**From:** Beverley Stubbington  
**Sent:** 10 June 2022 12:35  
**To:** 'barry.flannaghan < >  
**Subject:** SDNP/22/02392/LIS – Burton Mill Burton Park Road Barlavington West Sussex GU28 0JR

SDNP/22/02392/LIS – Burton Mill Burton Park Road Barlavington West Sussex GU28 0JR  
Resurface driveway.

Scale 1:500 at A4
Drawing number 002

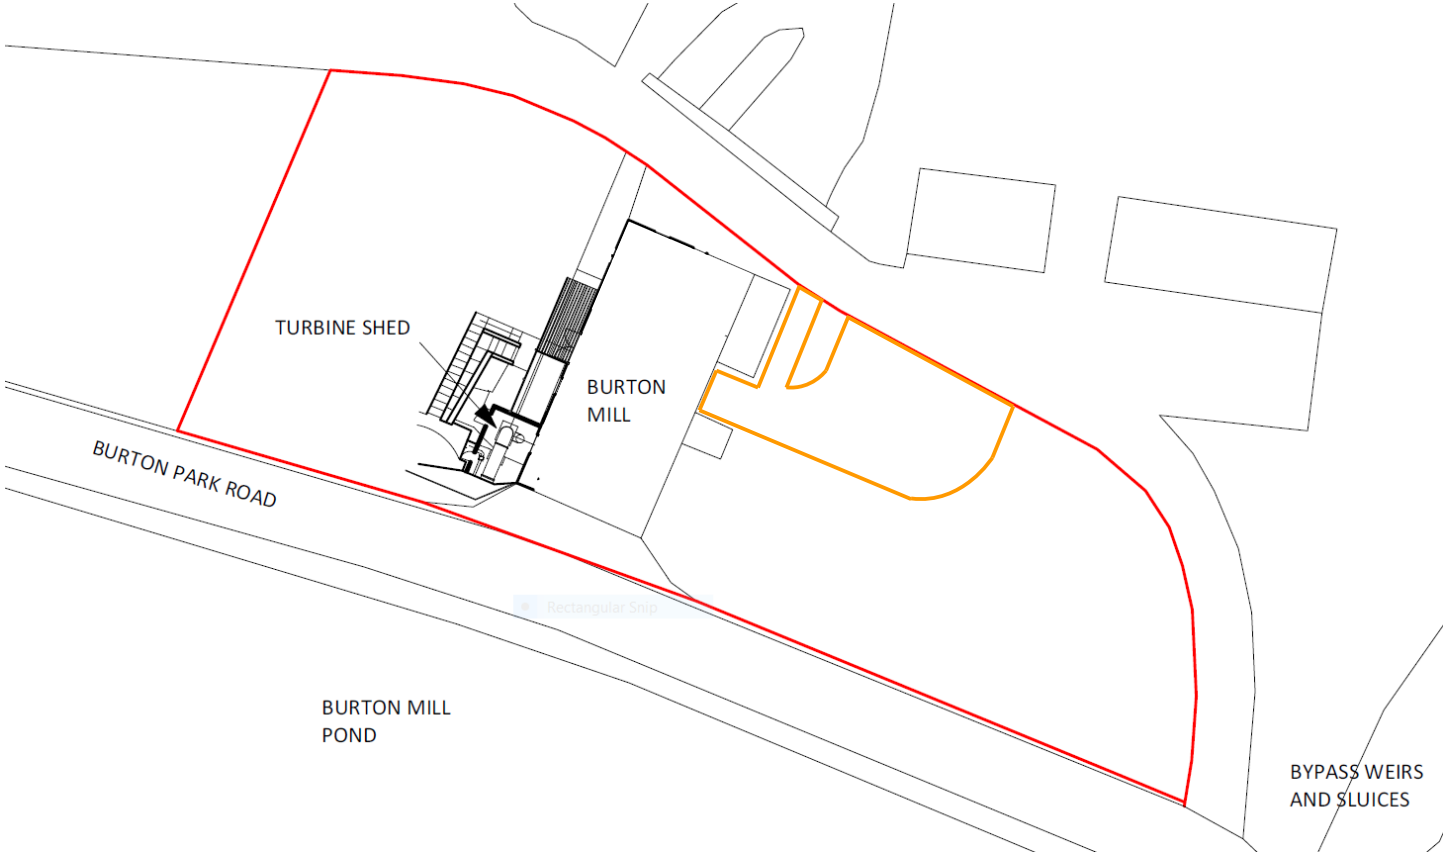
The submitted block plan (drawing 002) indicates the proposed hardstanding would have no physical connection to the listed building or any listed structures within the curtilage of Burton Mill. If this is the case listed building consent is not required and this application can be withdrawn.
